Re: Planning Application 19/0916

**Address: Camping Barn at Clark House Farm Fish House Lane Chipping
PR3 2GQ**

**Description: Change of use from holiday accommodation to residential
dwelling with minor alterations.**

Proposed Site Plan

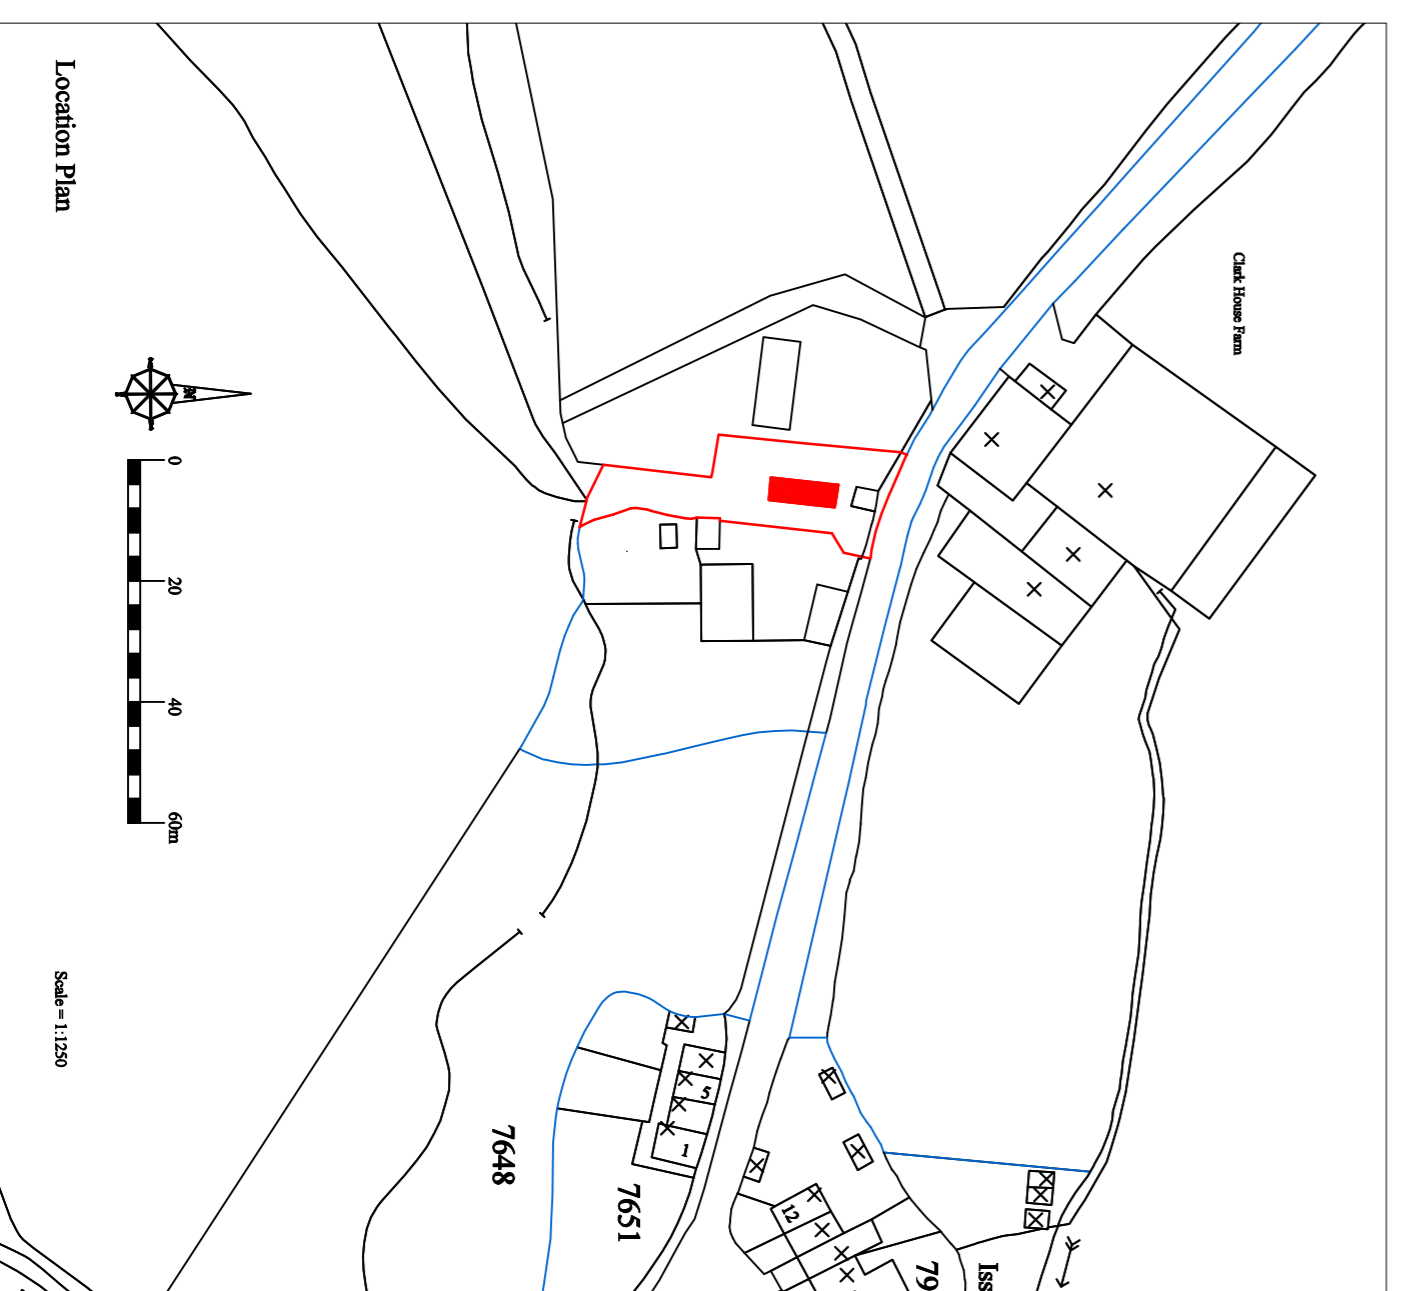
With respect to this application we would not wish to raise an objection to the principle of the change of use. However there is a concern that any vehicle may not be able enter and leave the site in forward gear.

In order to progress the application we would look for a plan at a suitable scale showing that there is sufficient space within the site to accommodate this manoeuvre.

1. As Fish House Lane is a classified road the Highway Development Control Section is of the opinion that all dwellings with direct access should have facilities off road for turning vehicles to ensure they can enter and exit the drives in a forward gear, in the interest of highway safety.
